RE: Durango at the Trails (File: C09D012), Unit 1
Grading and Drainage plans, Stamp Date 11-30-15 (Sheets 1 and 5)
Certification dated 3-23-2016

Re: Final Grading and Drainage Certification, Durango Unit 1
DRB Case No. 1010401, (C09/D012)

Re: Durango Units 1 and 2, Grading and Drainage Plan (C09/D012)

DURANGO
UNIT 2
INTERIM GRADING AND DRAINAGE PLAN

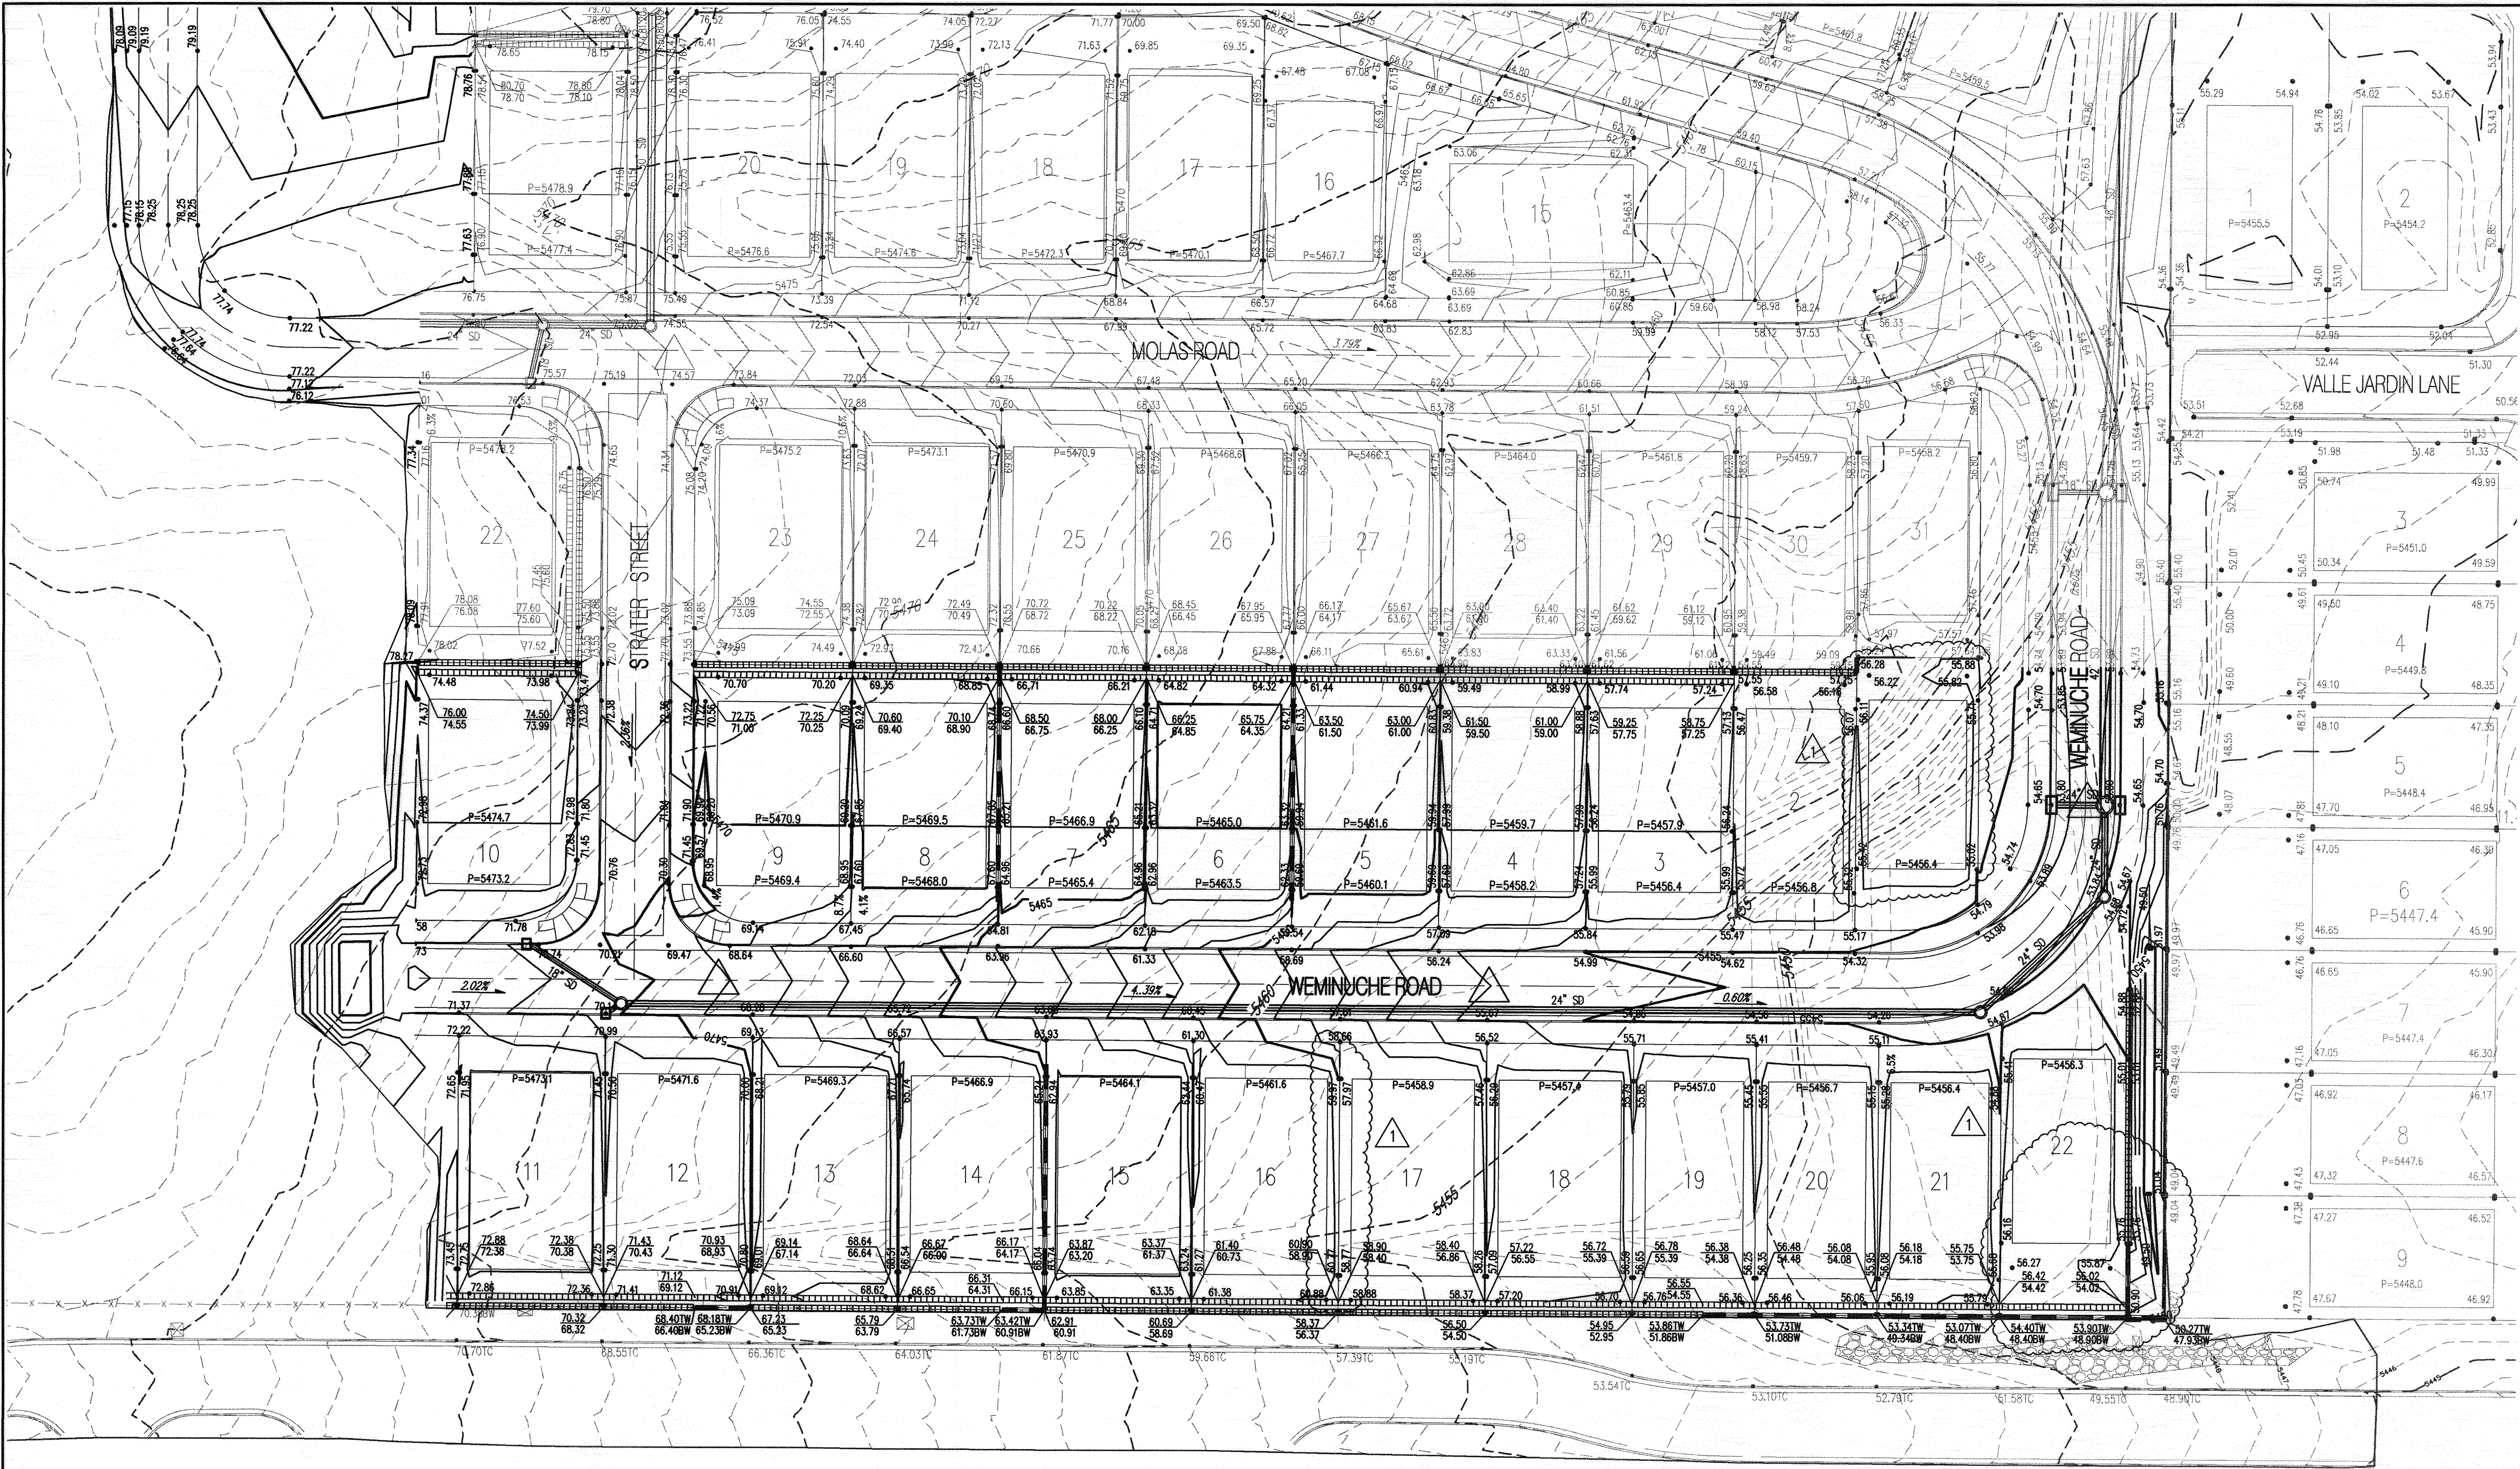
Please find attached a copy of the Hydrology Letter for the above referenced project. Note that the Interim Grading Plan is not included in the approval since we did not get a hard copy of it. Also, since the changes did not change the interim ponds, the approval for the latest submittal is still valid.
